From: Michael Eastham <Michael.Eastham@arun.gov.uk>
Sent: 22 December 2020 21:12
To: Planning.Responses <Planning.Responses@arun.gov.uk>
Subject: FW: Response To Application Number Y/139/20/DOC at Land south of Ford Lane and East of North End Road Ford BN18 0DS

Having now reviewed this and other related emails from Tilly Whishaw, my latest comments to Y/105/20 (CEMP and temporary construction access) are as follows:

Drawing Title
LEVELS AND DRAINAGE

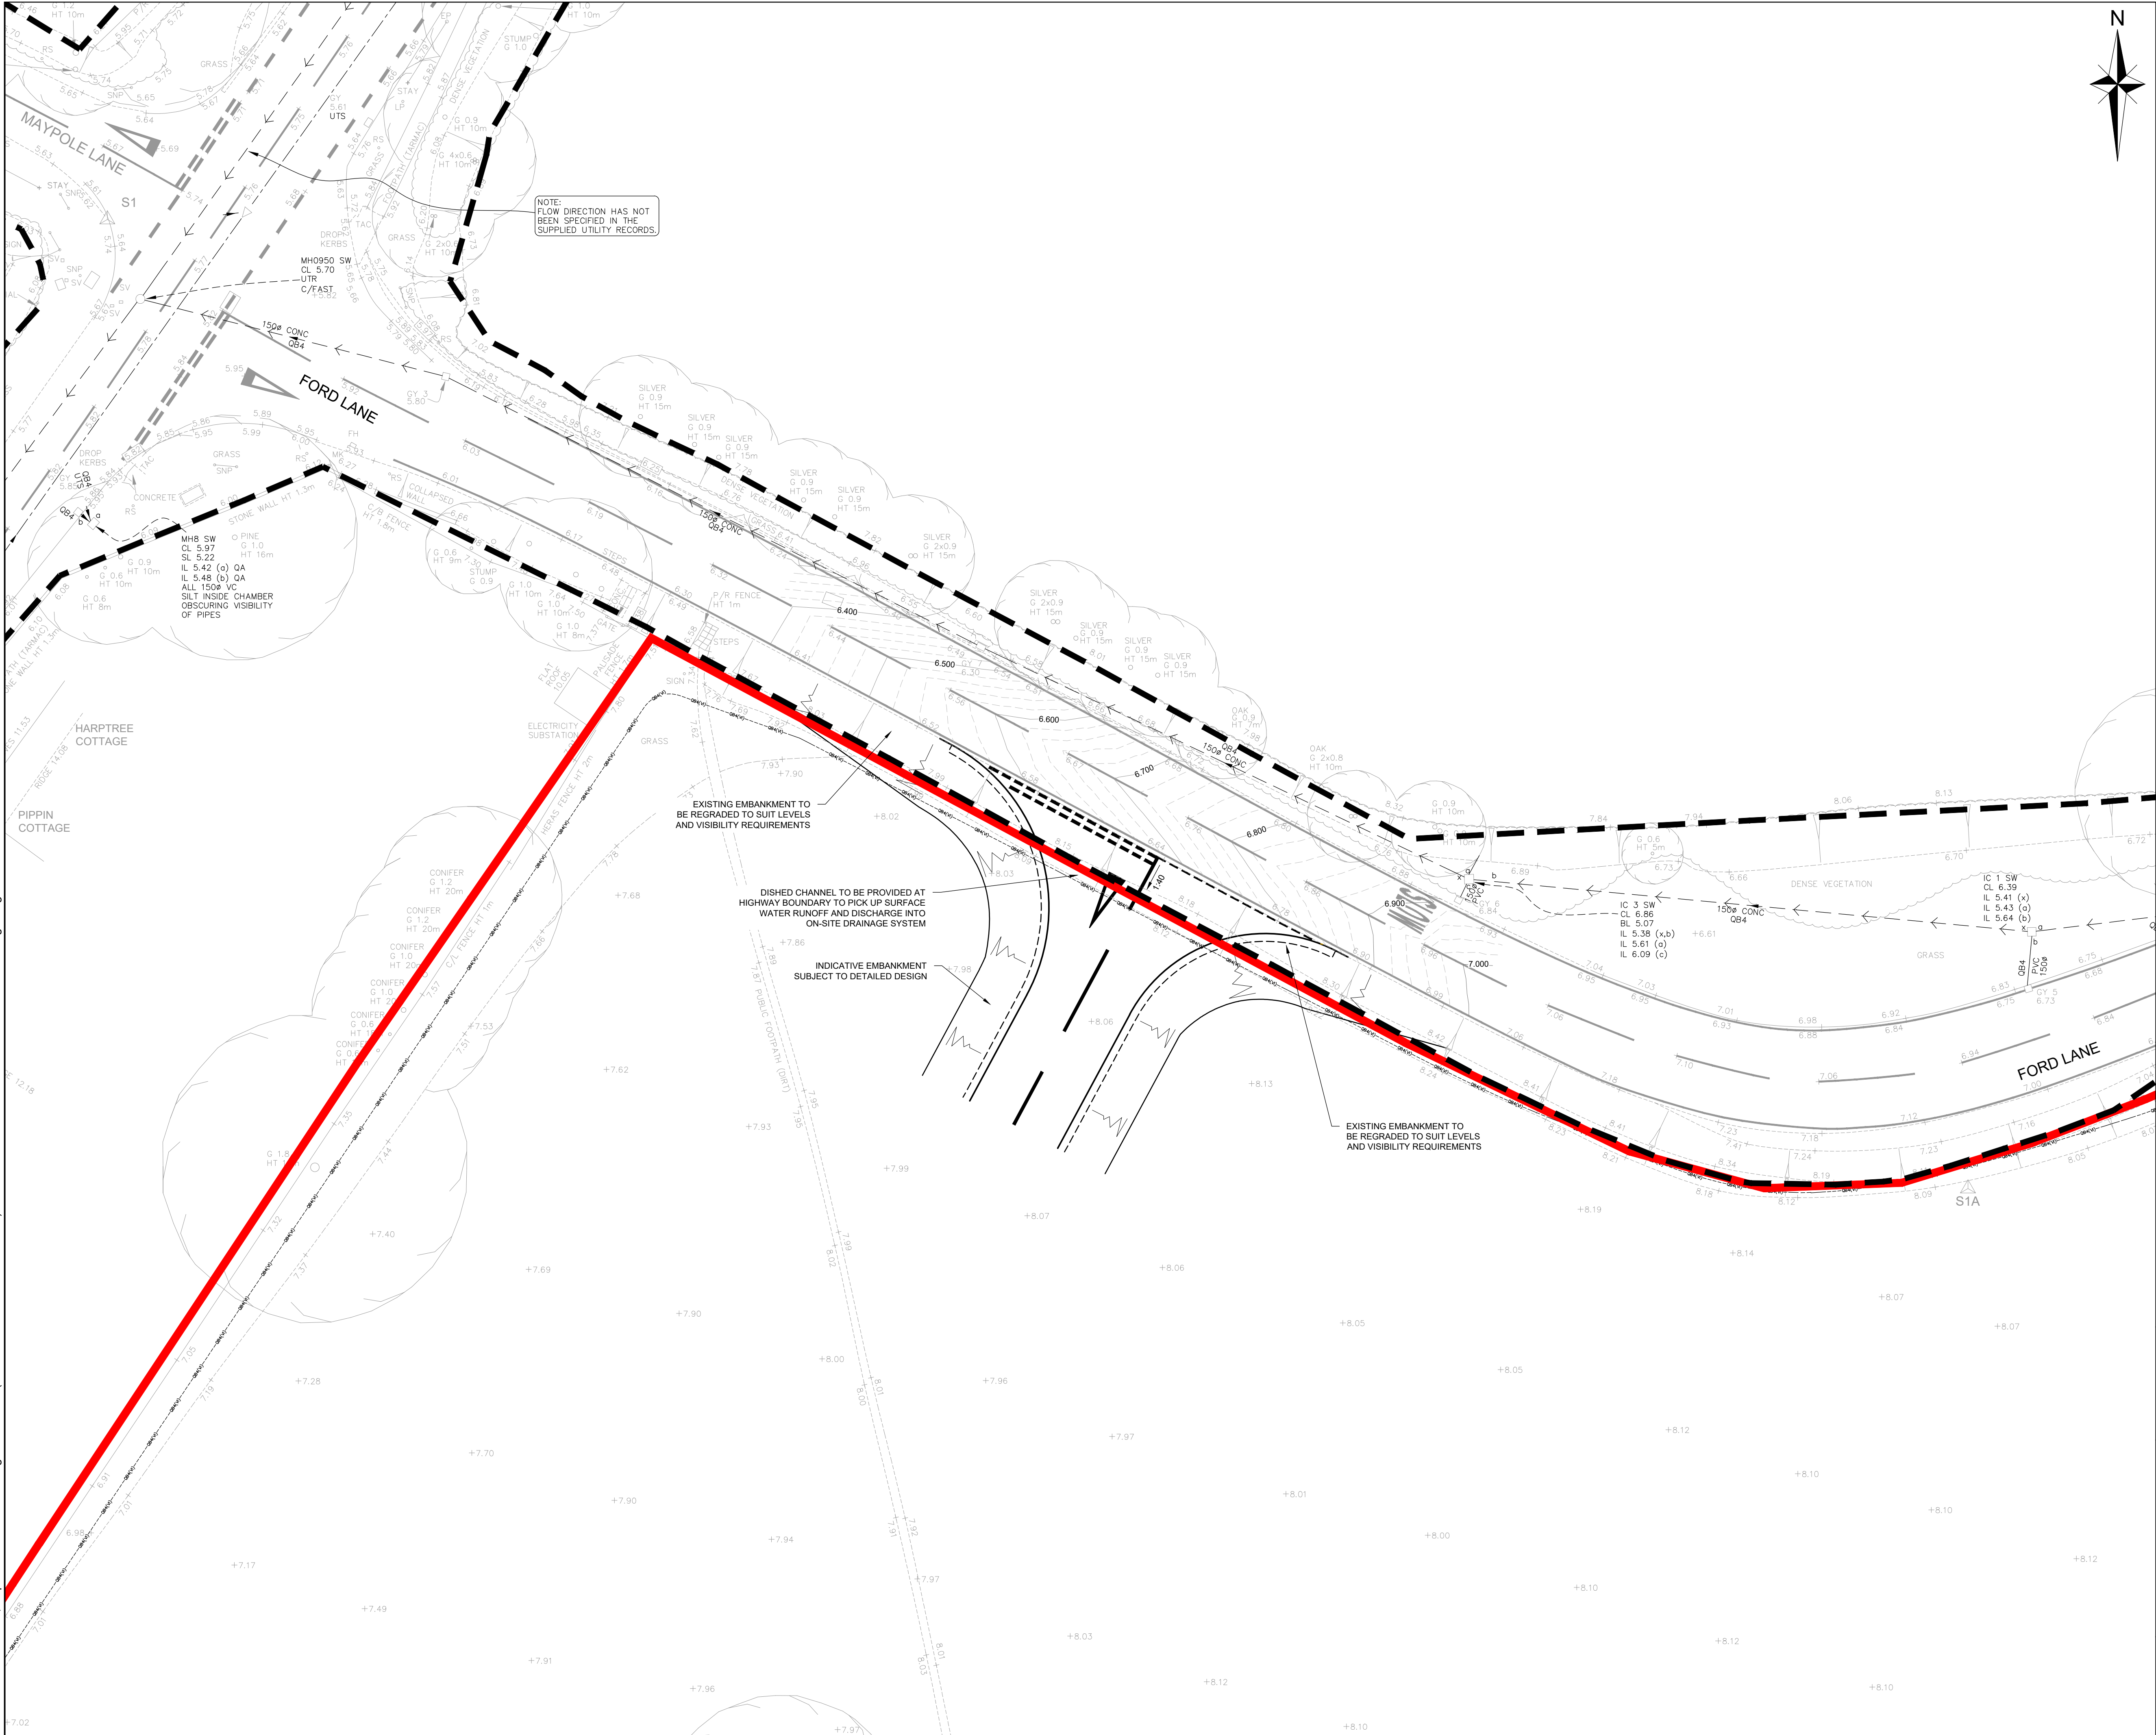
1. Reason for access confirmed by Tilly Whishaw.
2. Drainage details acceptable - will be checked in further detail as part of S38/278 stage.
3. Designer's Response requires updating to reflect current position.
4. Further information in support of visibility splays as requested previously still NOT provided.
